Planning Application No: 3/2026/0514

Proposal: Proposed change of use and refurbishment of existing building from restaurant to Sui Generis, Use Class E (e), Use class E (d) and Use Class E (g) (i) spaces including internal alterations and reconfiguration. Conversion and refurbishment of 2no outbuildings to Use Class E (g) (i) spaces. Installation of electric vehicle charging points. Installation of CCTV/ANPR camera column. Installation of automatic bollards to site entrance. Replacement of existing external lighting columns with new. Proposed bin and cycle stores. Removal of roofed timber enclosure to rear of outbuildings/terrace.

Location: 76 Whalley Road, Clitheroe BB7 1EE

7391 - P05 B

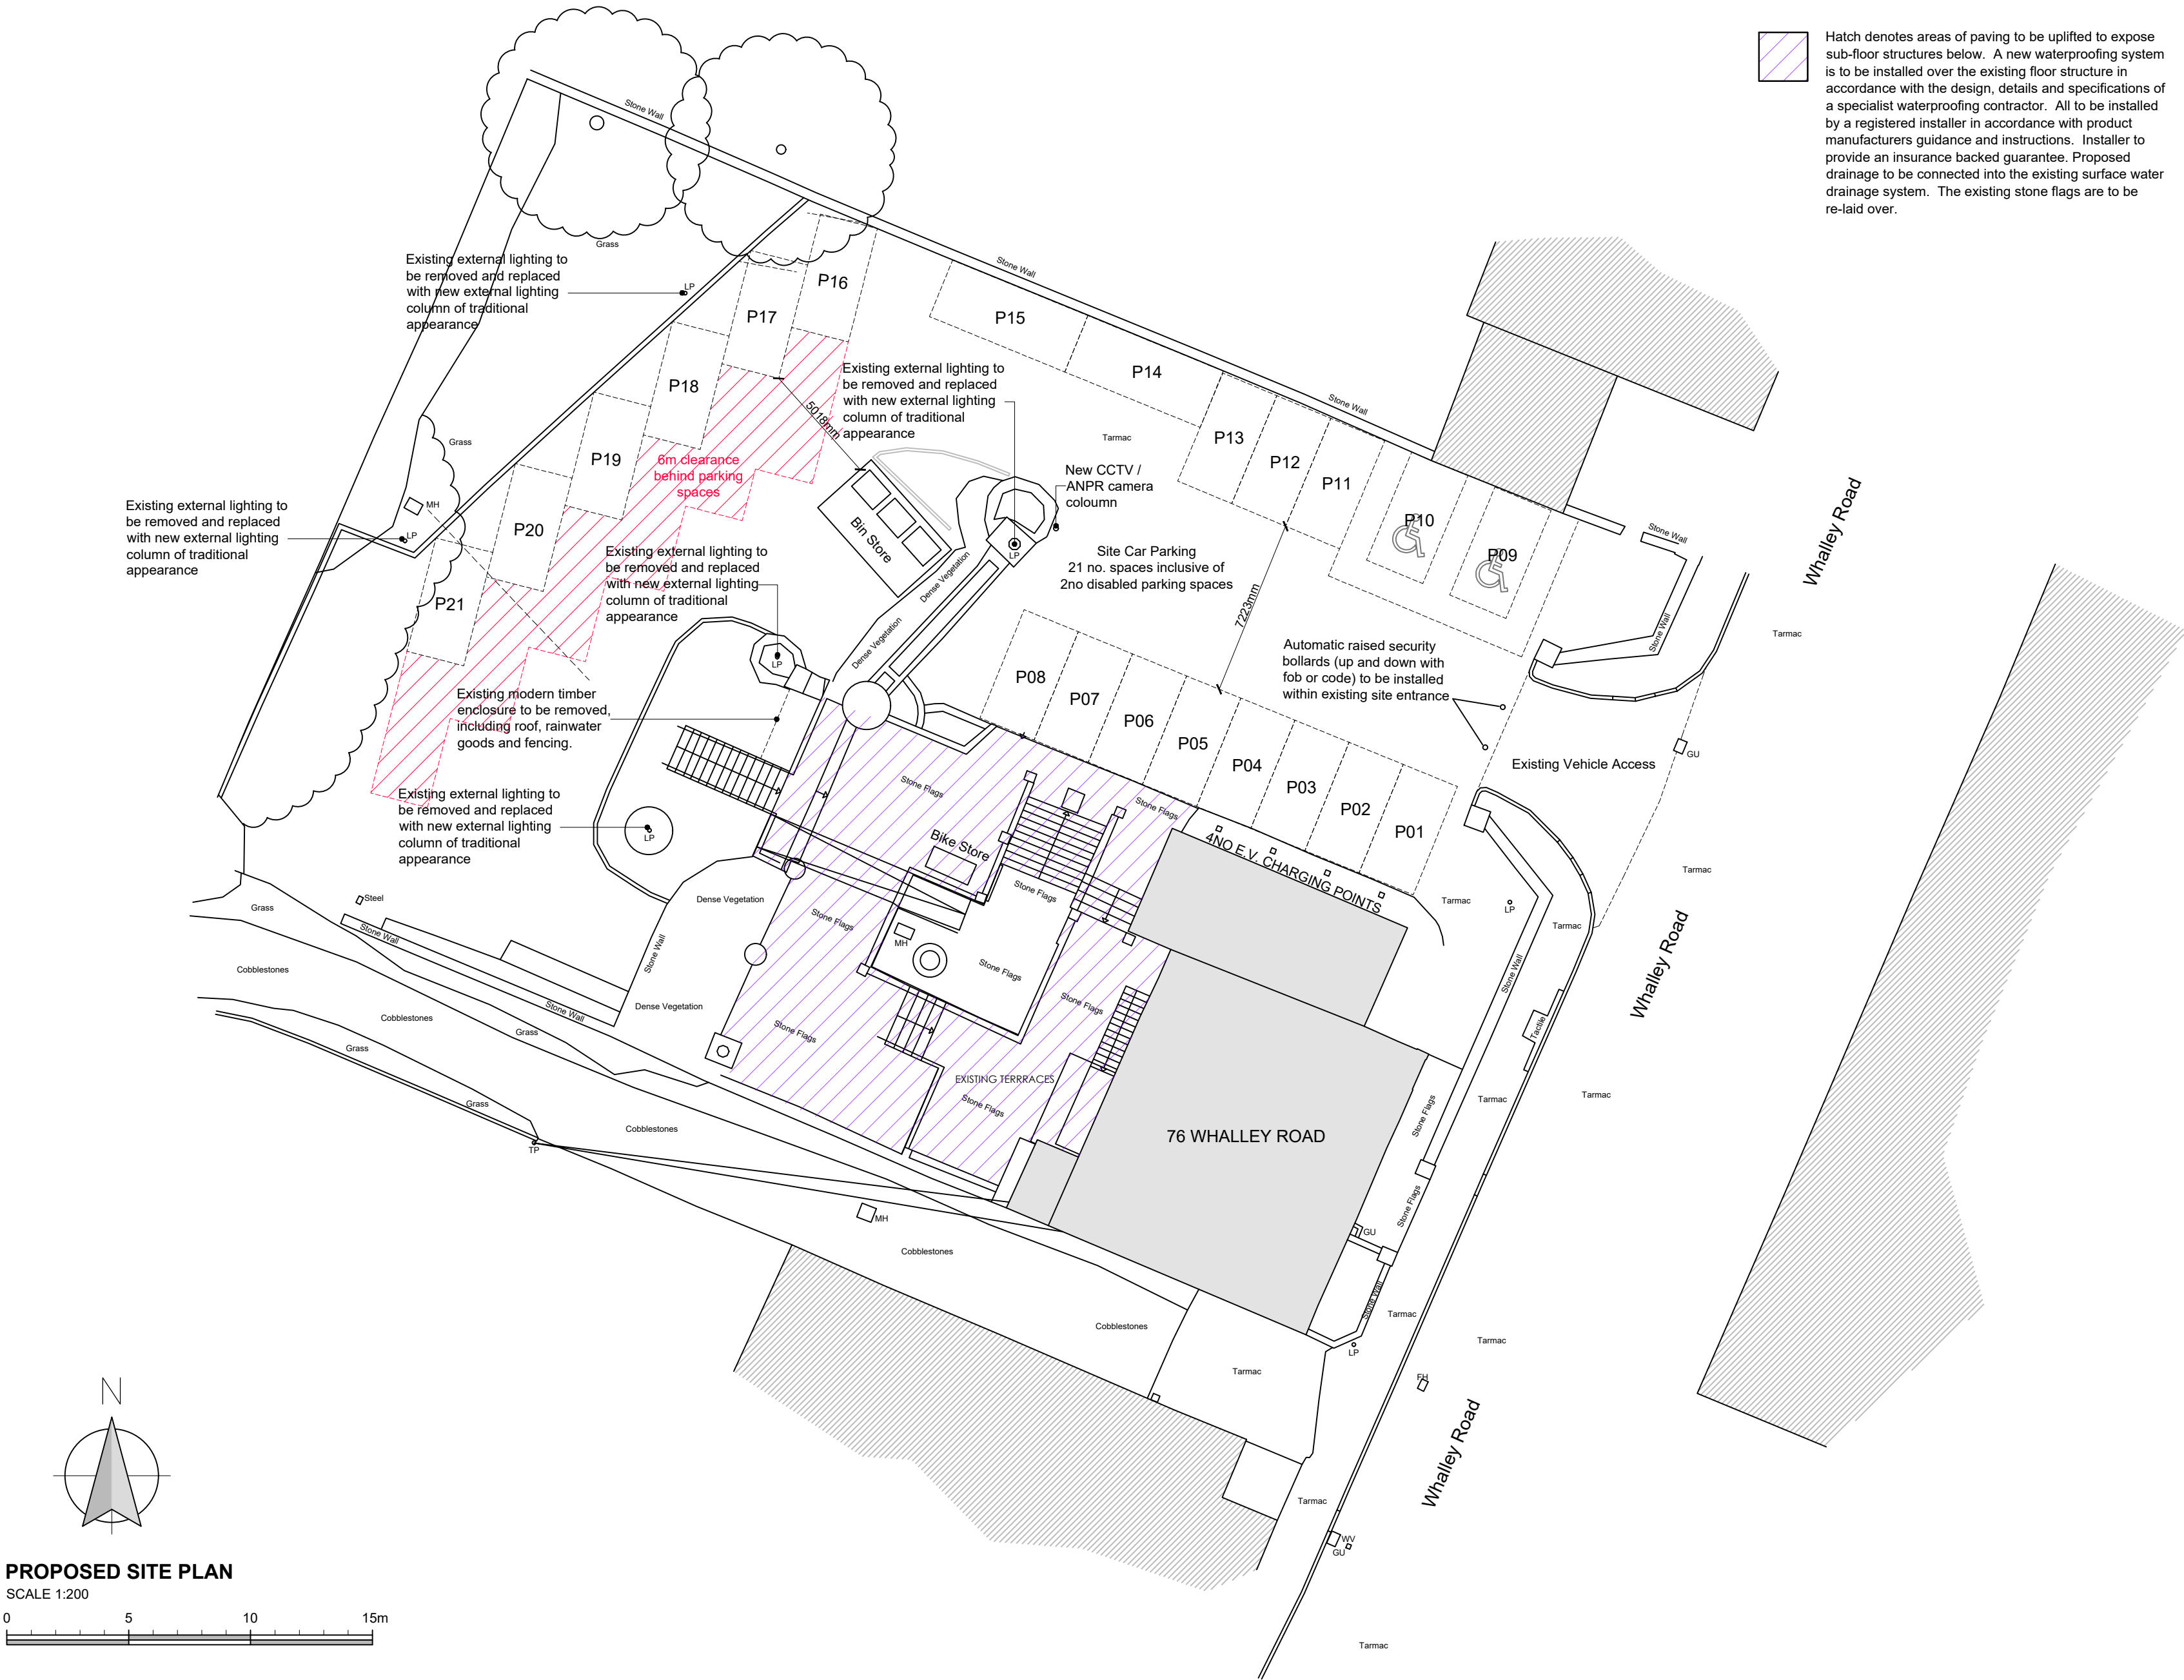
The layout of the two disabled parking bays (Nos 9 and 10) has been amended and now complies with national guidance. Bays 14 and 15 have also been increased in length to 6m each as requested. Echelon parking is now proposed for bays 16 to 21. The overall parking provision has been reduced from 22 to 21 spaces. The highway authority previously recommended that parking be allocated at the following levels:

This totalled 22 spaces, which can still be accommodated as there is room for a parking space adjacent to the bin store area. This could be used as a flexible parking space.

The proposed bike store has been moved from the front to the rear of the building, where this would potentially have natural surveillance, either from the building or the car park. As no details of the store have been submitted this can be controlled by condition.

The highway authority requested a swept path plan demonstrating that a refuse vehicle would be able to enter and leave the site in forward gear and without impacting on the parking layout. A swept path plan (Drawing 7391 – P08) has been submitted which shows that a refuse vehicle can enter and leave the site in forward gear. However, this will require the full removal of vegetation along the south western boundary to allow this manoeuvre – extract from plan below

Signs should also be erected within the manoeuvring areas stating that these should be kept clear.
